Re: Proposed Single Storey to Rear.

At: 25 Herons Way, Birdwell, Barnsley. S70 5SF.

Application No: 2014 / 0328. Application Date: 24th. March 2014.

Dwg. No: 642-11 rev.A

PROJECT	S/Storey Rear Extension
CLIENT	Mr. & Mrs. K. Morley
TITLE	Working Drawings
ADDRESS	25 Herons Way, Birdwell, Barnsley. S70 5SF.
DRAWN BY	g99
SCALE	1:100: 1:50
DATE	May 14
DRAWING No	642-11
REV

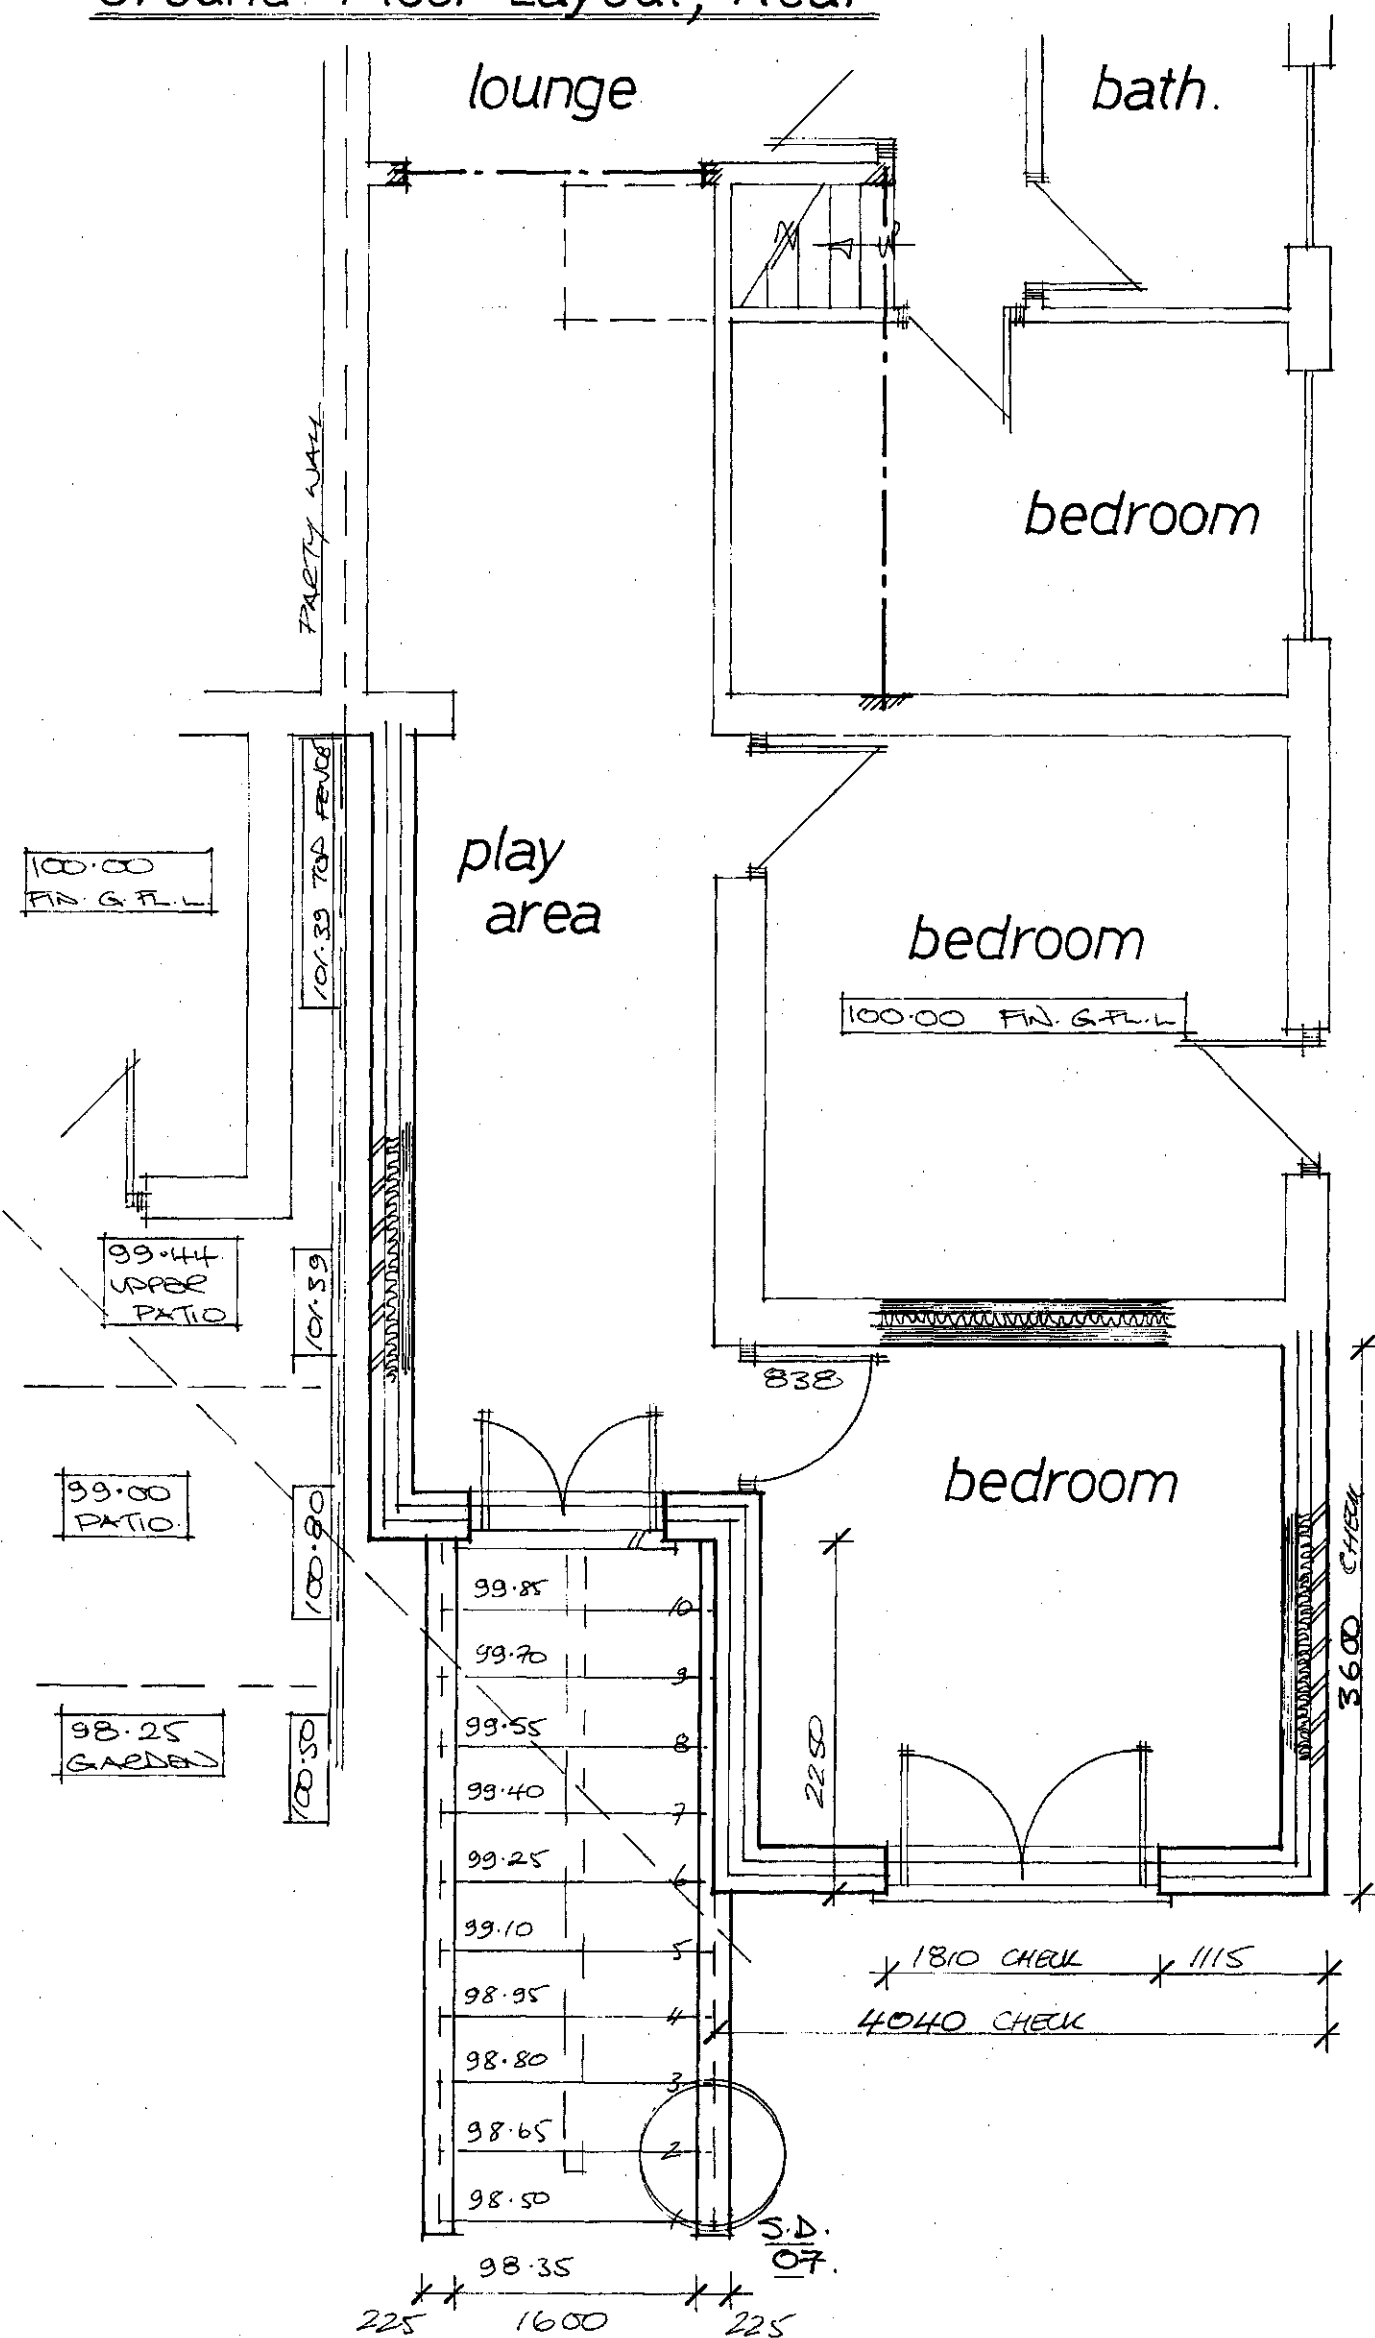
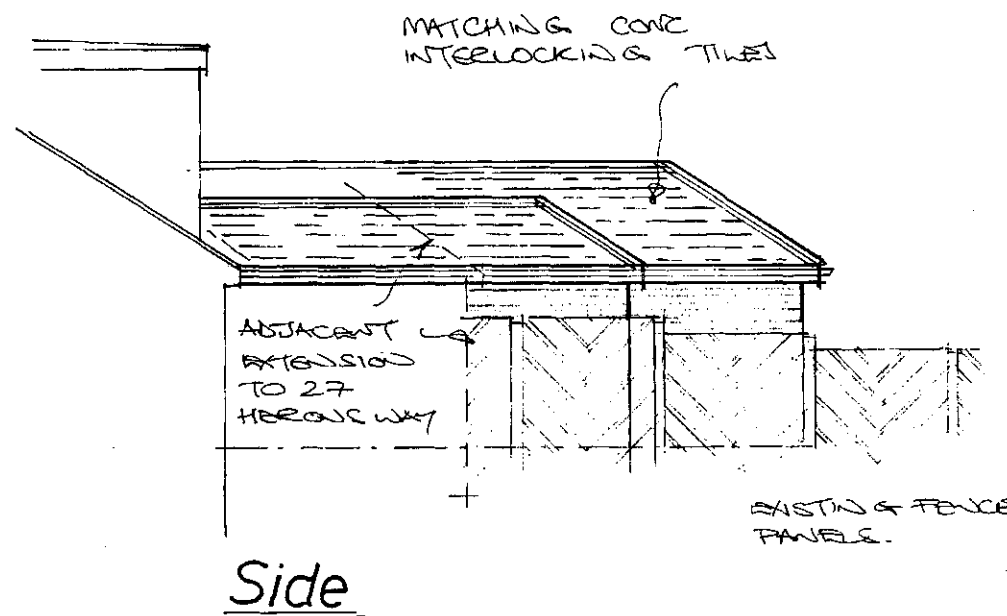
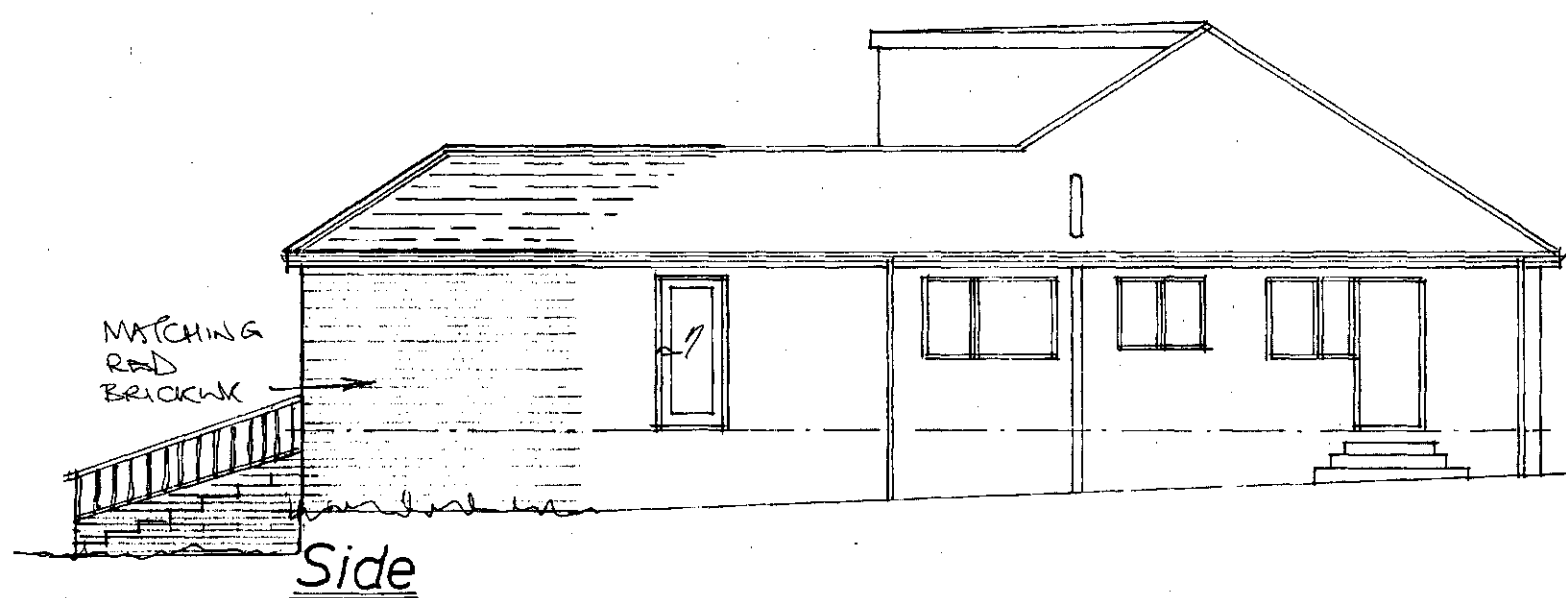
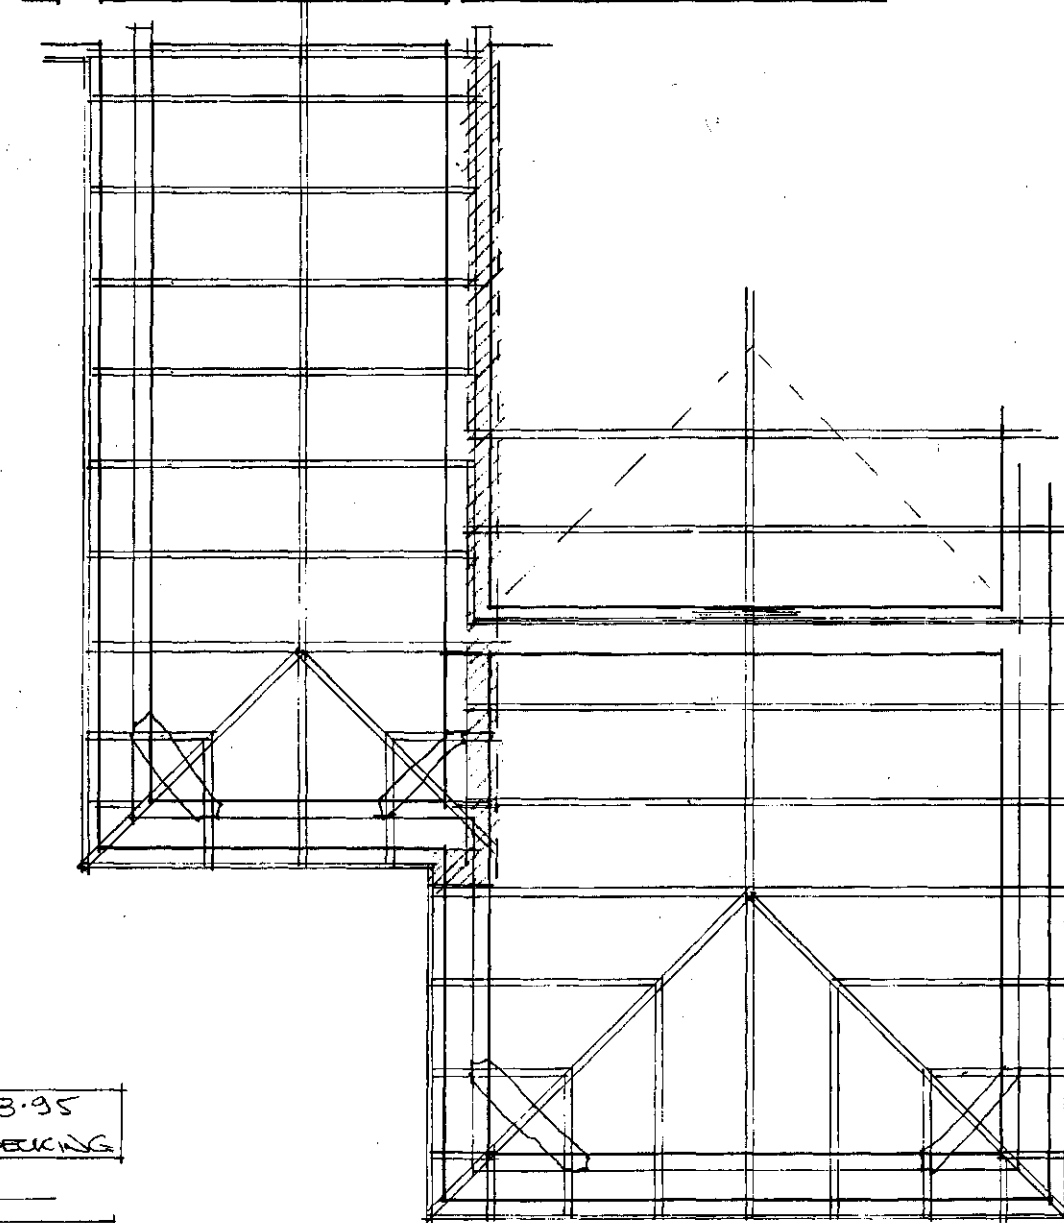
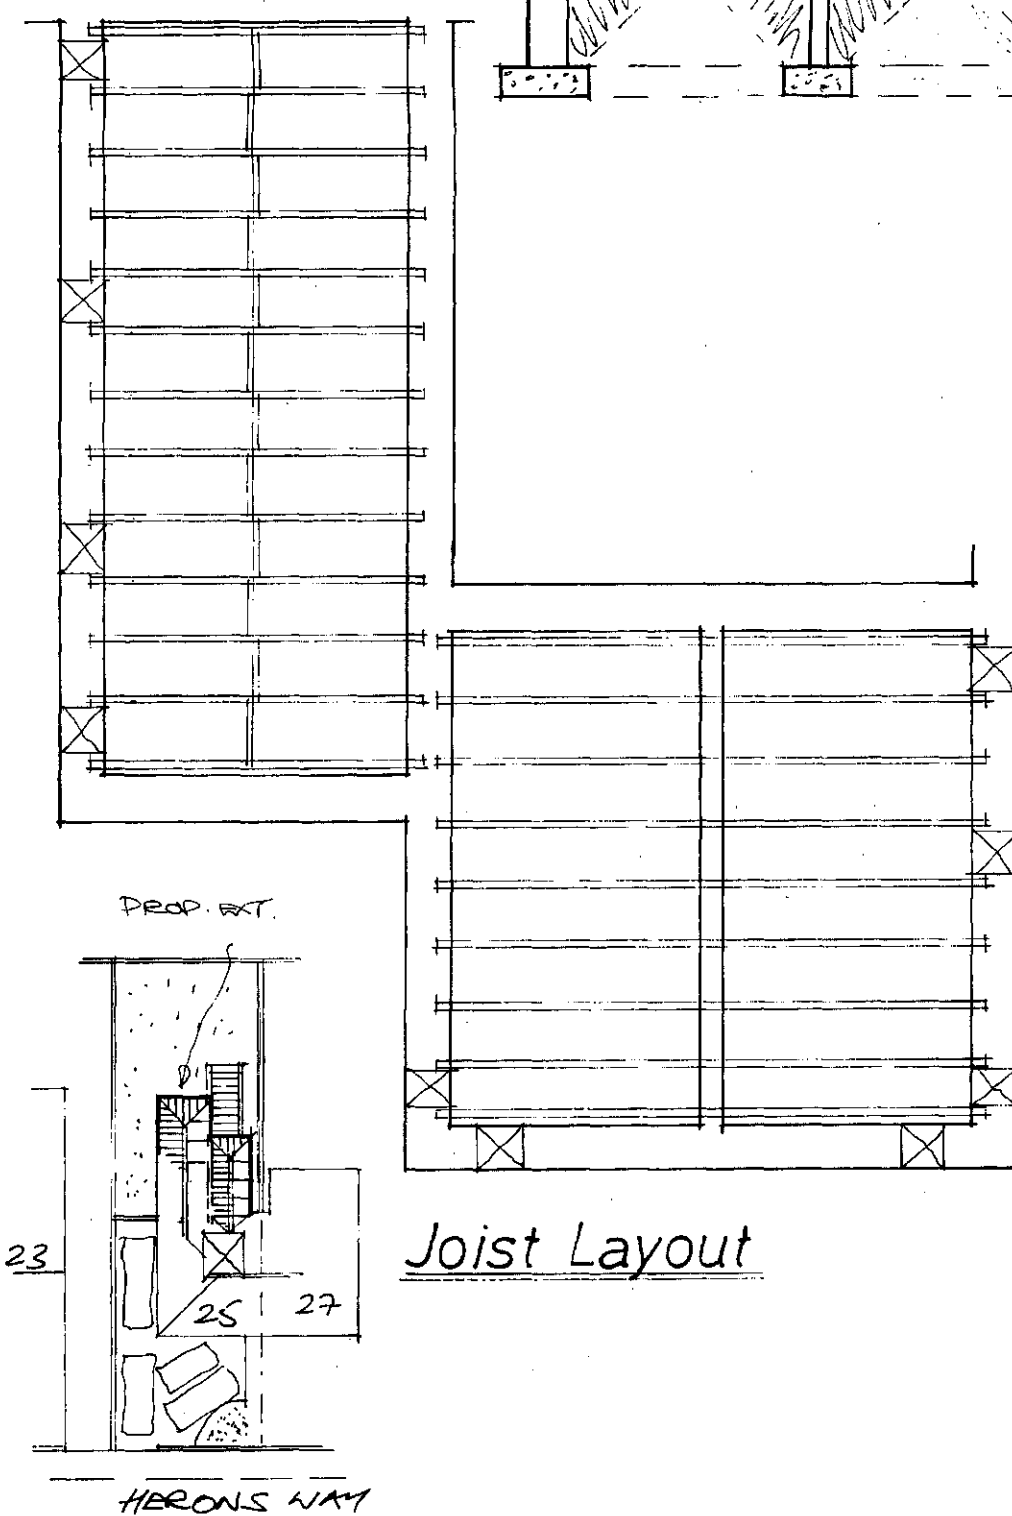
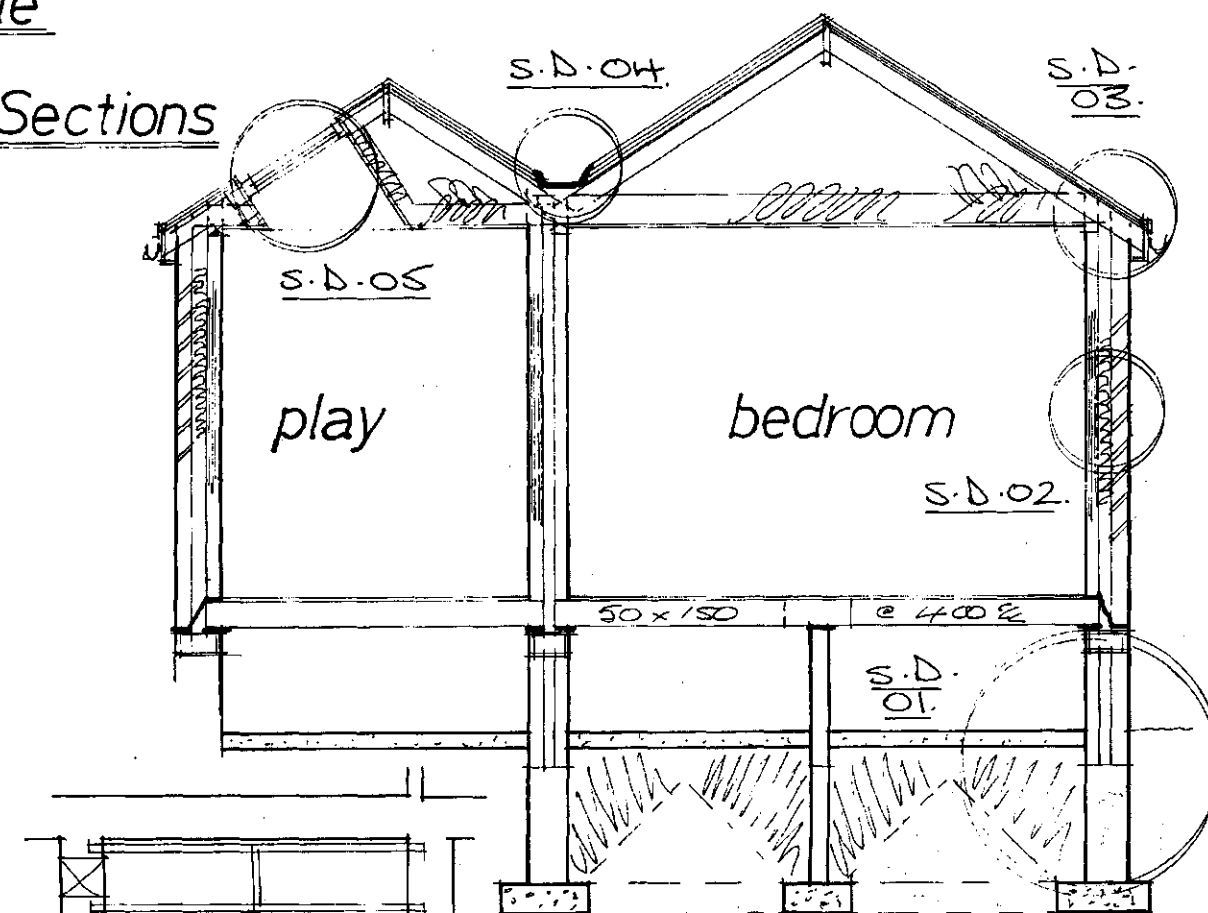
- i) reduction of rear extension – to reduce impact from adjacent boundary / dwelling;
- ii) re-location of bedroom extension away from adjacent boundary;
- iii) provision of external steps as indicated.

Also note that we have indicated on the amended layout not only various spot levels as discussed but also we have shown that these proposed extensions are not within the requirement for 45 degrees from the adjacent extension French doors.
